Application No: EP/60/21/HH
Site Address: New Lodge Seaview Road East Preston BN16 1LX
Description of works: Erection of two side dormers

Thank you for your internet representation made on 13th July 2021 which has been recorded as an objection with the comments as follows:

PROPOSED SIDE ELEVATION 1:100

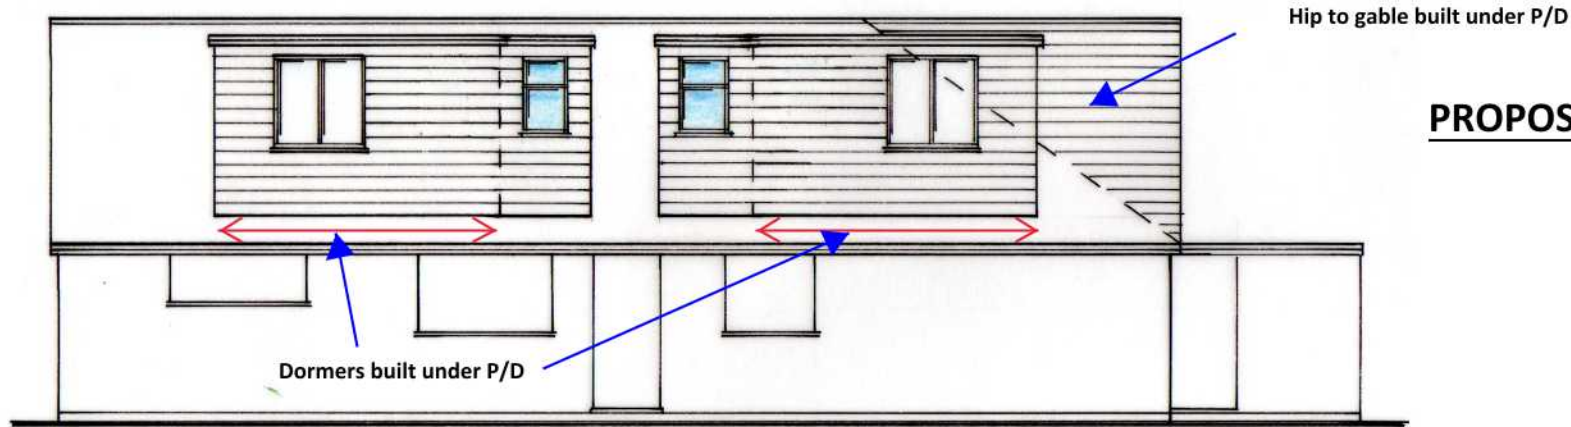
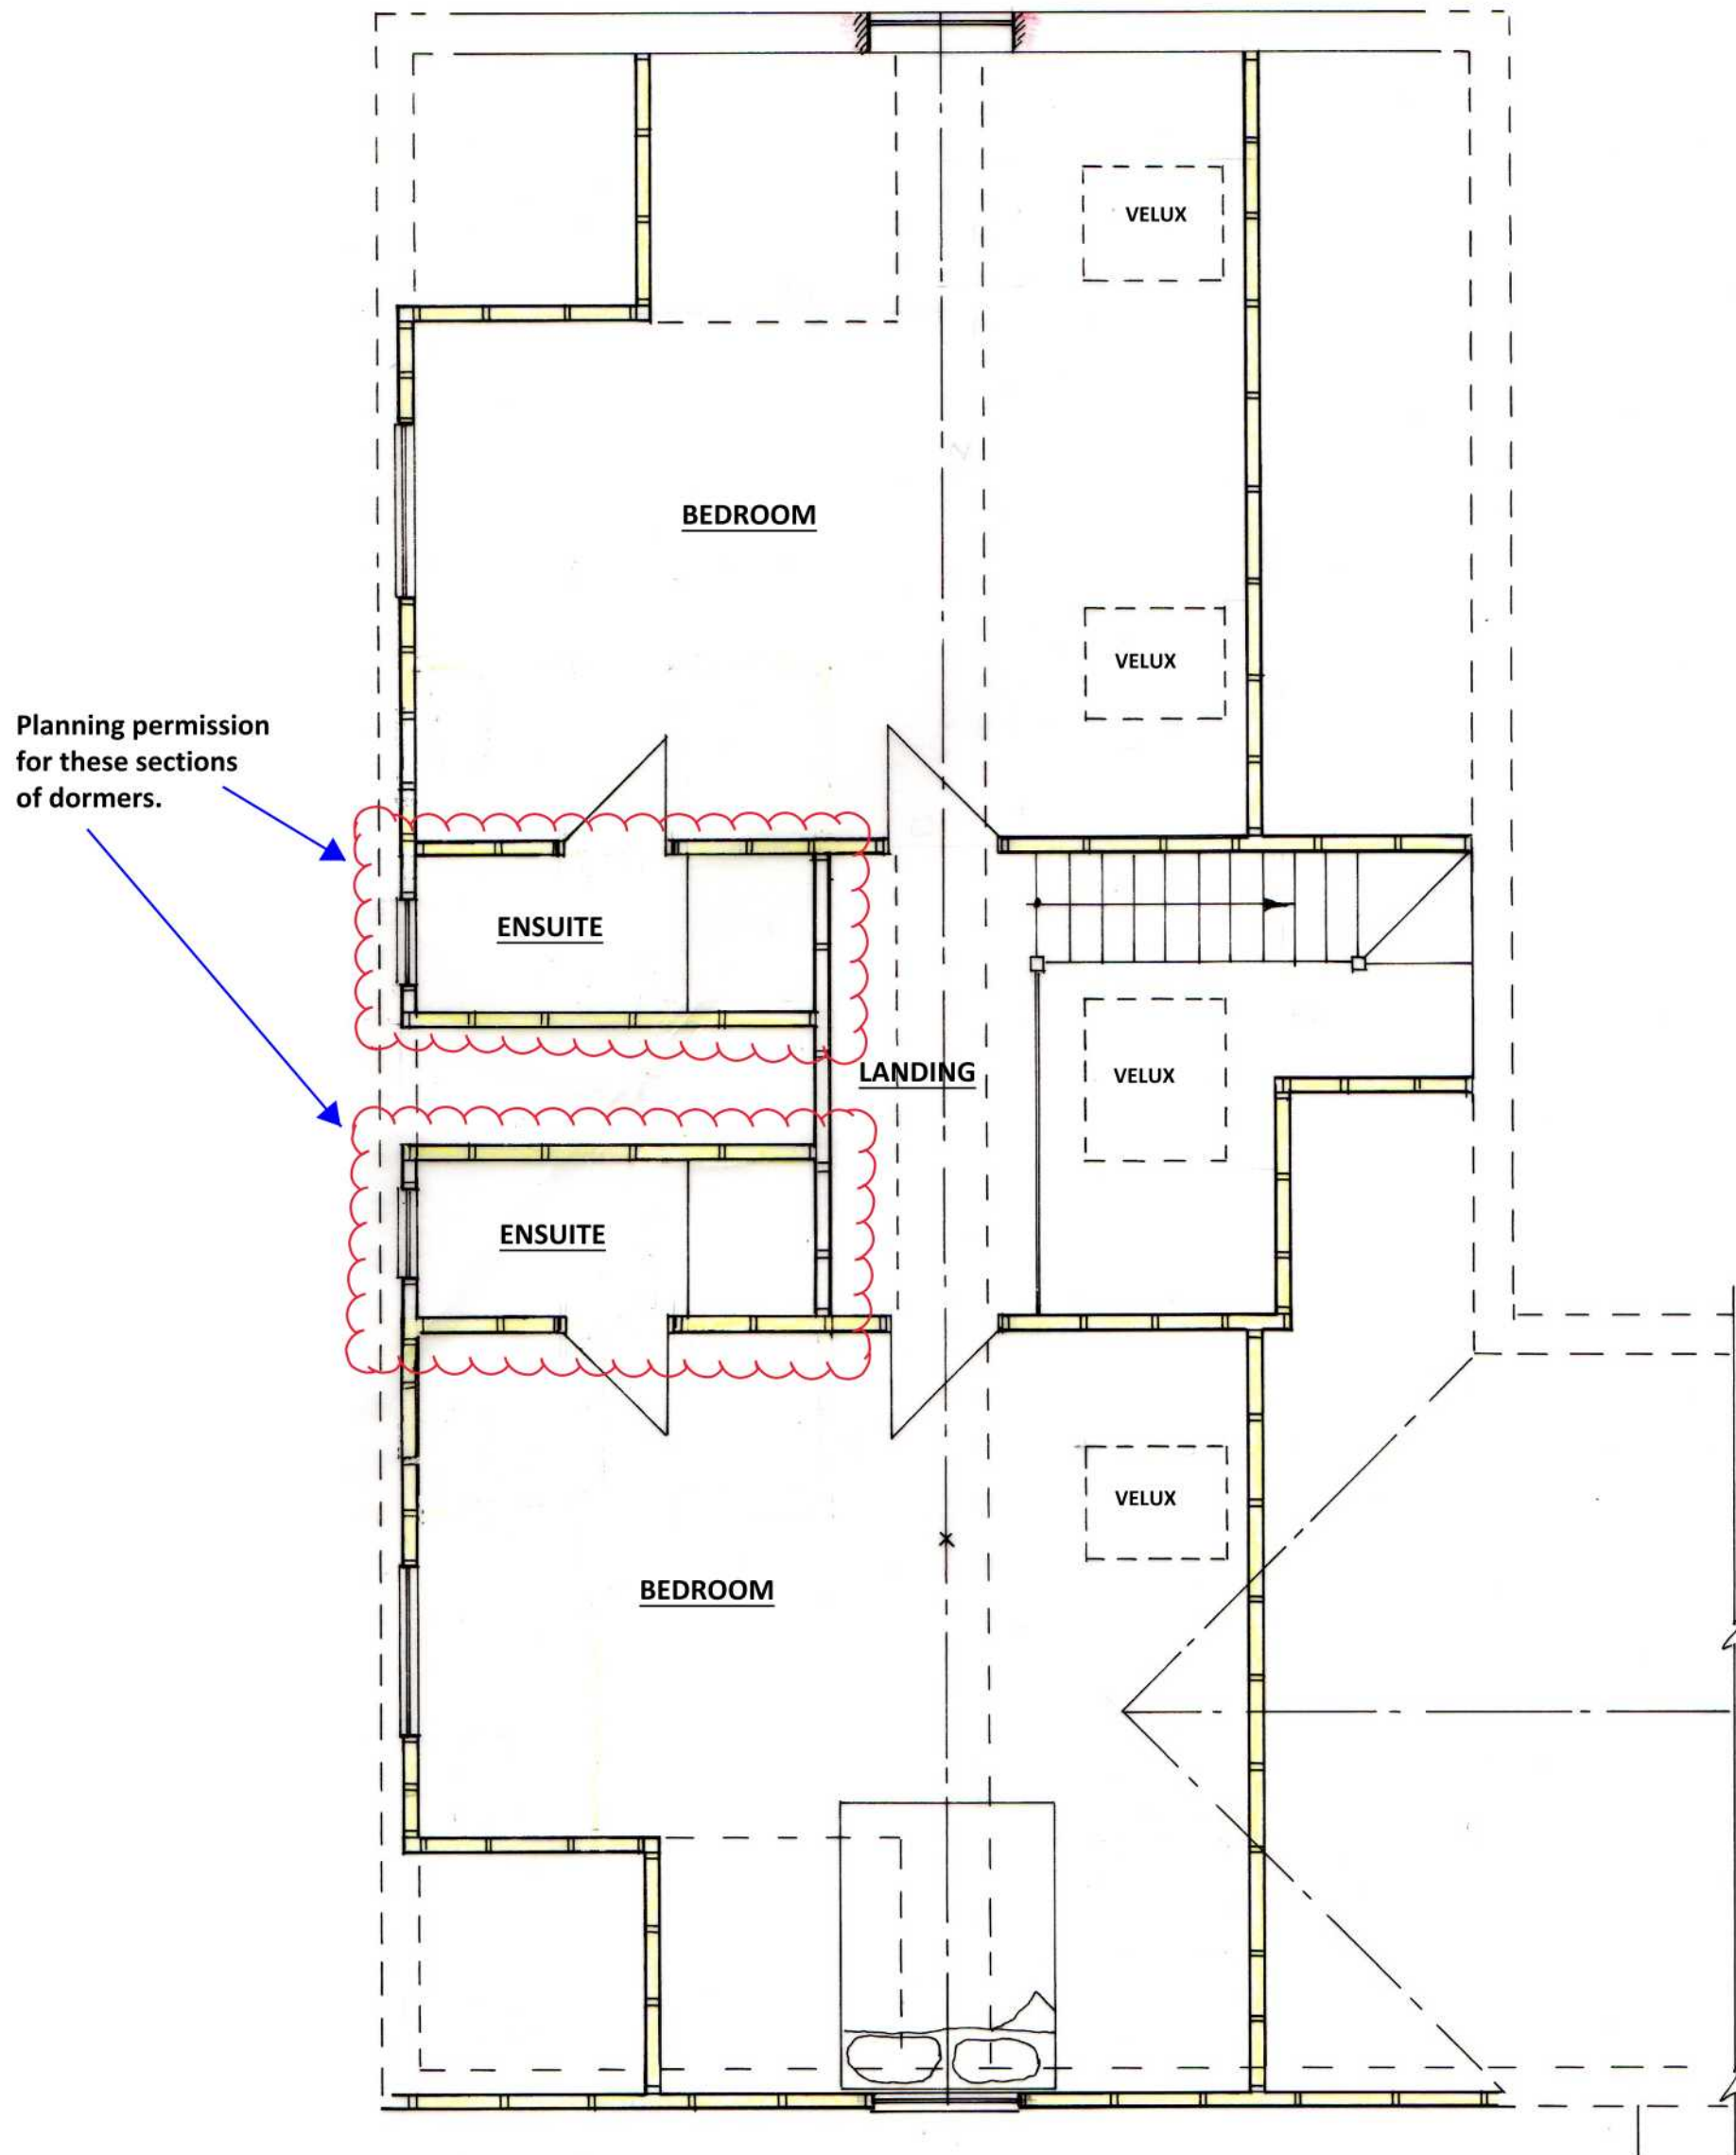
Gable end extension - Due to the building line of the proposer being approximately 1.5 metres from the neighbouring property the proposed gable end extension would compromise light into the neighbouring property. In addition to this the gable end extension including dormer will face directly into the adjacent properties living area.

Side facing dormer - Side facing windows must be obscured glazed glass to maintain privacy and opening sections must be at least 1.7 metres above floor height, this submission does not appear to be adhering to this limitation on any proposed development of a side facing dormer, contrary to legal, planning and moral perspective (privacy)

The current submission for planning permission does not take into account the fact that the proposed dormer does not look into any area of their own property and only looks into the adjacent property from approximately 1.5 metres away from the boundary wall, all the open spaces will subsequently be clearly visible if approved with a clear view directly into the neighbouring property's lounge, kitchen, 2 bedrooms upstairs and 1 bedroom downstairs.

Glazing to provide privacy in any side dormer submissions are usually rated on a scale of 1-5, with 5 providing the most privacy, side windows in particular should be obscured glassed with a minimum of level 3 (permitted development). Due to the unusually close proximity to the rear of the adjacent property we would ask that consideration be given that any approval of glass windows be rated at a scale of 5 to ensure privacy of the adjacent property and that the opening sections be at least 1.7 metres above floor height.
